Recommendation Report for Planning Permission for Works or Extension to a Dwelling

REF NO: BR/162/17/HH

LOCATION: 11 Newhall Close
Bognor Regis

PROPOSAL: Proposed side & rear extensions (resubmission of BR/50/17/HH).

Scale	1:100	Drawn By	C.R.-B
Date	JAN. 17	Checked	
Drawing Number	1388-4

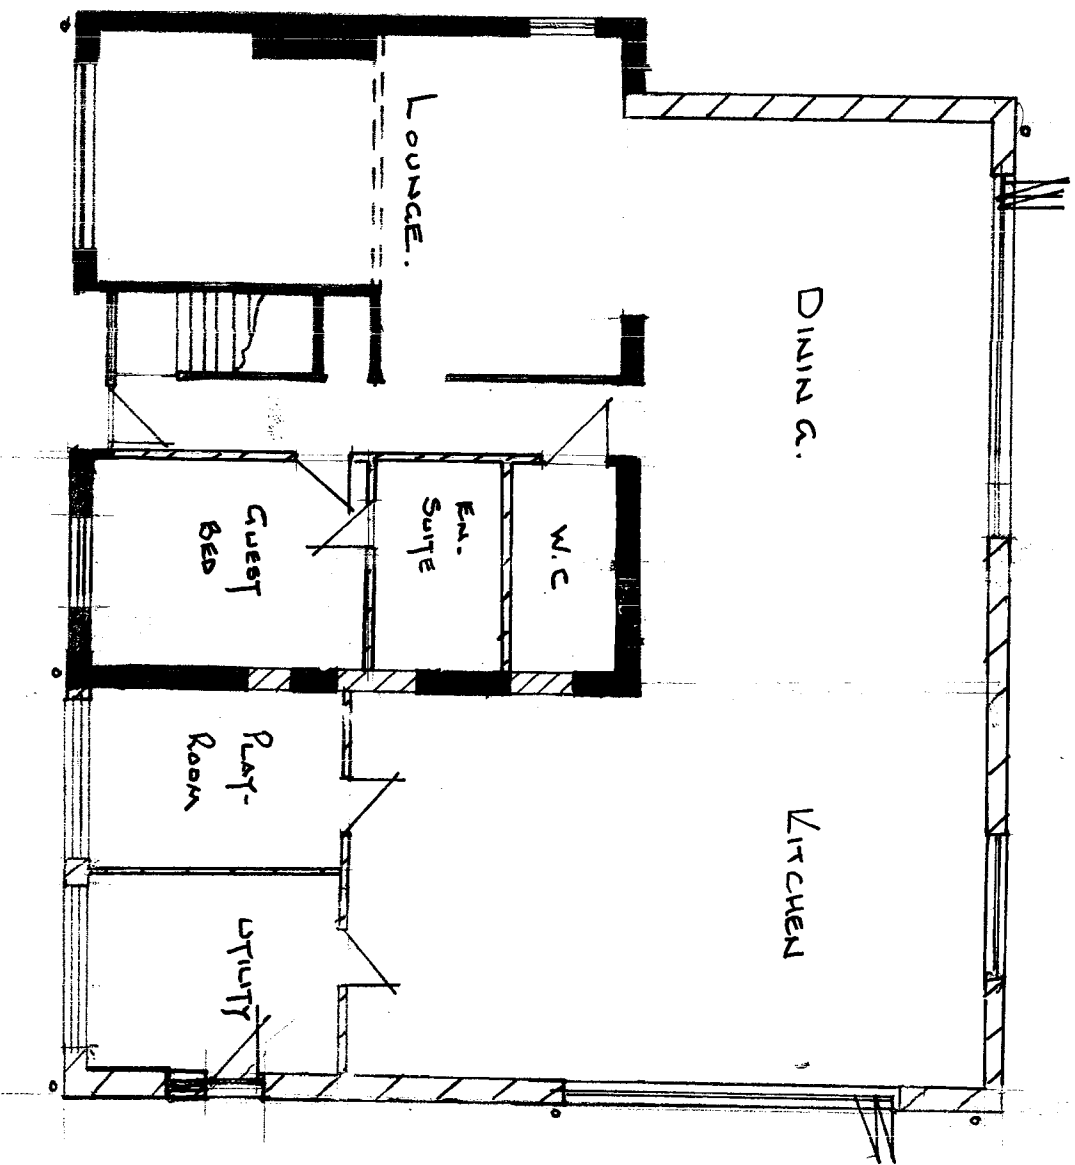
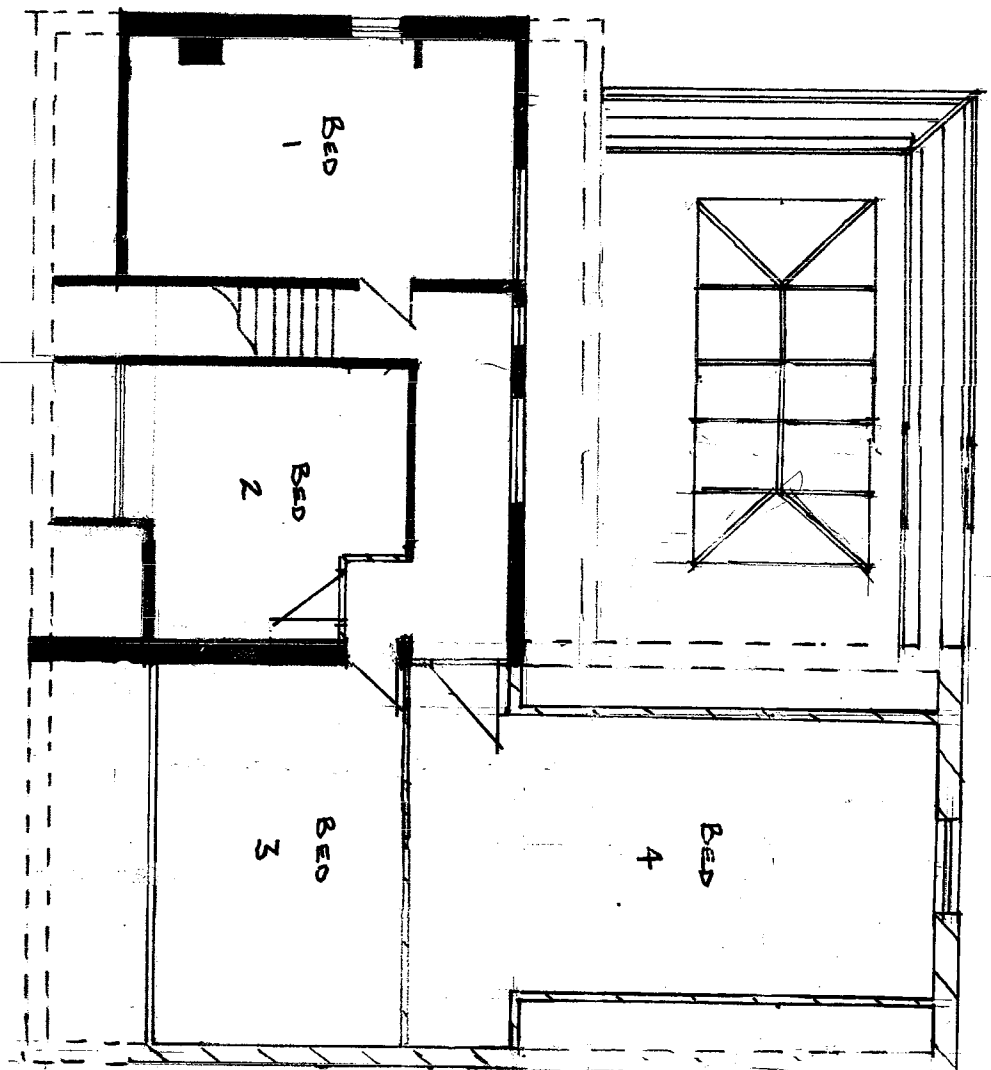
-lack of details of windows being shown on plans and potential for the applicant to insert additional roof lights.

No details of windows to bedroom 3 have been provided. Should roof lights or a dormer be proposed a further planning permission would be required amending this application, should permission be granted.
